**KIRKLEES METROPOLITAN COUNCIL
INVESTMENT & REGENERATION SERVICE**

DELEGATED DECISION TO DETERMINE PLANNING APPLICATIONS

Reference No:	2022/60/93563/E
Site Address:	New North Road, Heckmondwike, WF16 9DW
Description:	Outline application for erection of residential development
Recommending Officer:	Emma Thompson

SITE PLAN 1:500

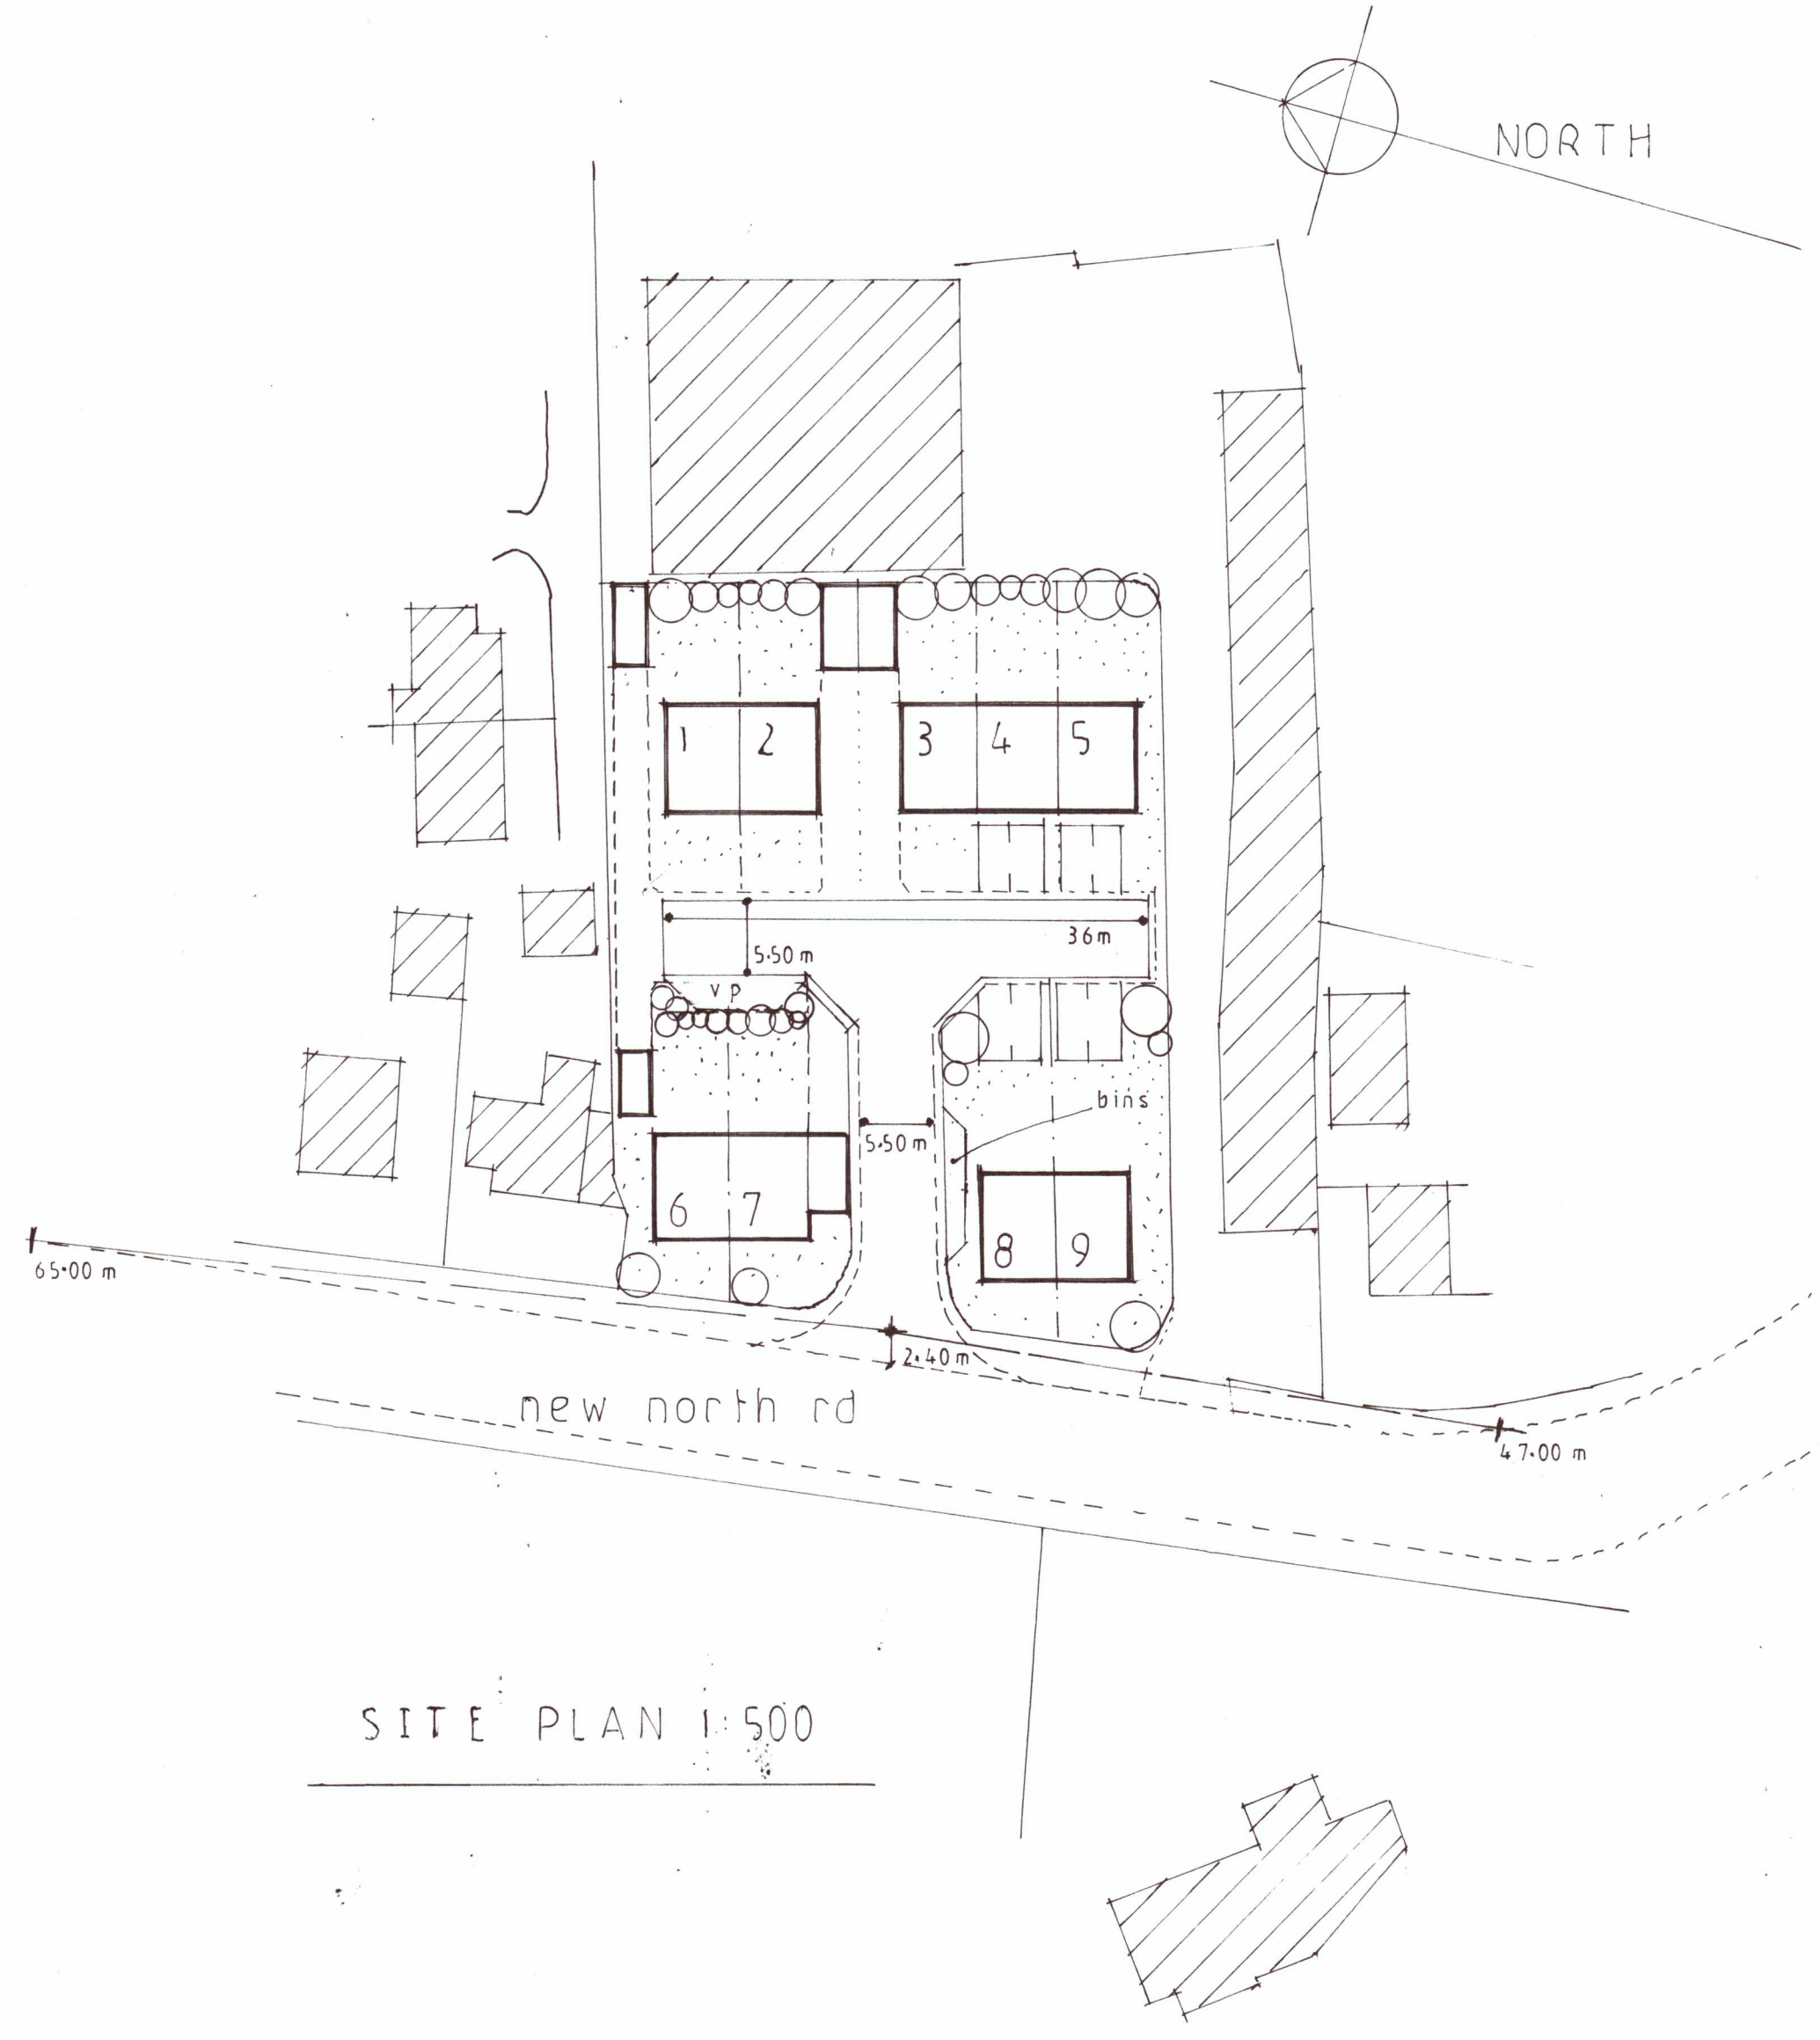
The application does not include appearance, layout or scale for consideration, but an indicative plan has been received that shows 3 pairs of semi-detached properties and a row of three all of which are two storey. The plan shows associated garden space to the rear of each of the 4 dwellings along with parking. Whilst in general the plan could be acceptable it should be noted that the House Builders Design Guide Principle 11 and 12 states that parking should not dominate building frontages. The parking at plots 4 and 5 should be reconsidered for reserved matters.

The plan shows bin presentation point adjacent to Plot 8 towards the front of the site. This will require screening to ensure the development avoids any visual harm to the street.

The application is in outline with access included for consideration. An indicative plan accompanies the application showing the position dwellings. The indicative layout would not meet the standards set in not achieving respective distances particularly Plots 1-3 to the building at the rear which is less than 12 metres. The location and/or design of Plots 1 and 2 do not achieve a distance of 12 metres from existing habitable room windows. The units could be designed and located to avoid the loss of amenity to nearby occupants meeting, in general, policy set out in the SPD.

Access to the proposed development is from New North Road. The indicative plan prepared by JA Oldroyd and Sons Ltd show 9 three bedroomed semi-detached and terraced houses served by a 5.5m wide access road and turning head. Each of the proposed houses is shown to have a least two off street parking spaces with one visitor space shown and a bin collection point at the site access.

Sight lines 2.4m x 65m (north) and 2.4m x 47 m(south) are shown from the site access onto New North Road. These sight lines are shown to be within the existing width of footway along New North Road and are considered acceptable given the 30-mph speed limit along this section of road.

Whilst the layout shown on the indicative plan is cramped with no pedestrian access shown from New North Road, the turning head is narrow and unlikely to be sufficient in size to turn a large 11.85 m refuse vehicle and insufficient visitor parking is shown the only matter to be considered is access.
